DEVELOPMENT REVIEW BOARD TRANSPORTATION DEVELOPMENT Standard Comment Sheet

DRB-1002259

Project Number: 1002259
Application Number: 02DRB-01515

DESCRIPTION OF REQUEST: Divide R1 land into 2 lots. Sketch plat.
SKETCH PLAT

PLAT OF
BLOCK J-1965*
OF

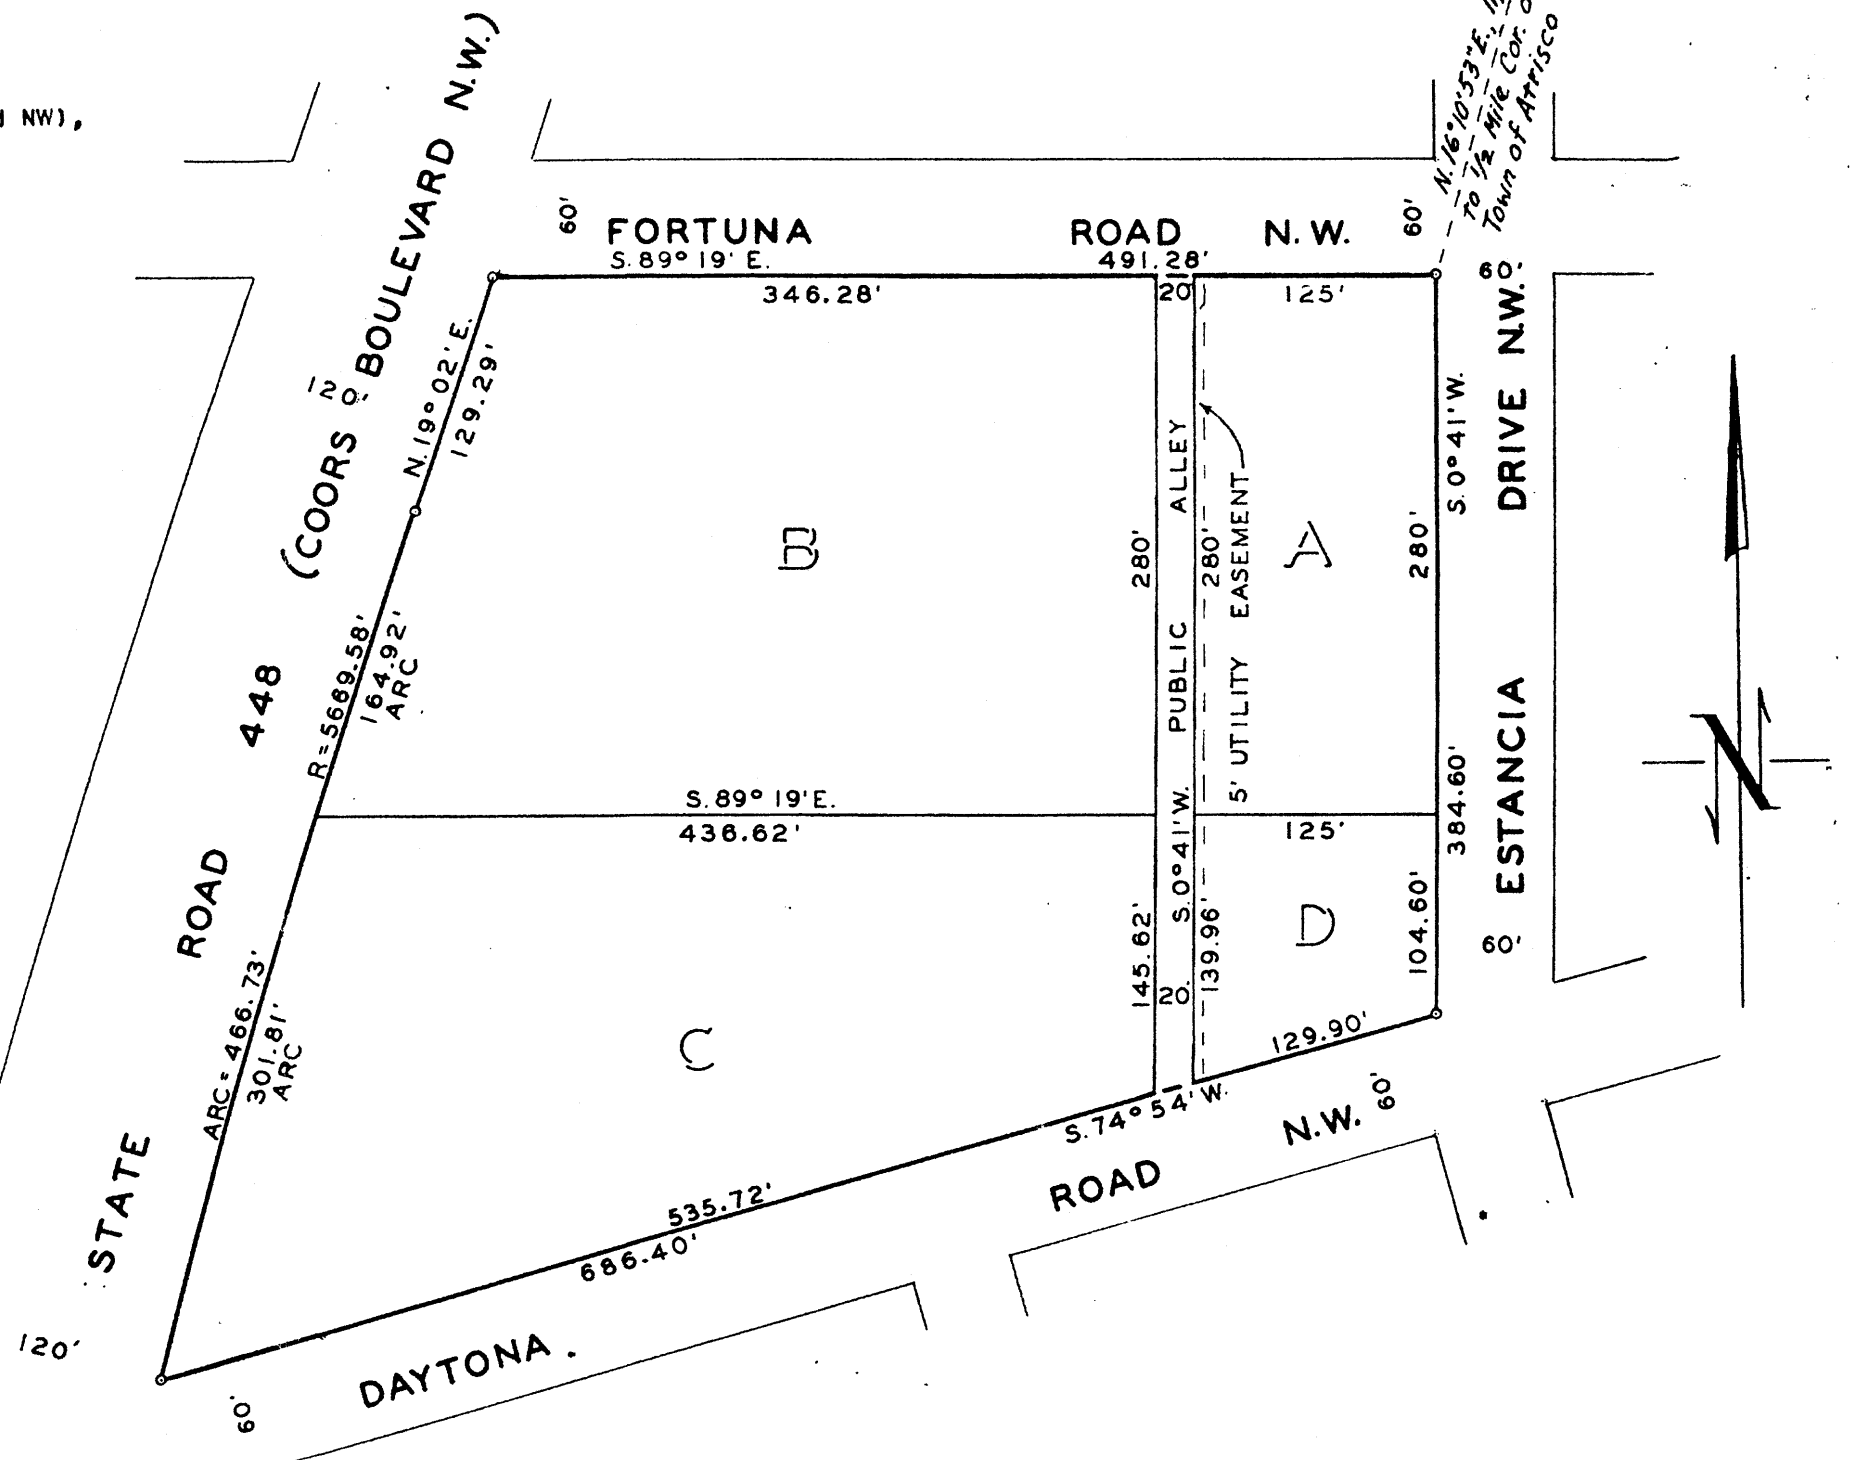
No adverse comments.
 Are you planning on vacating the alley?
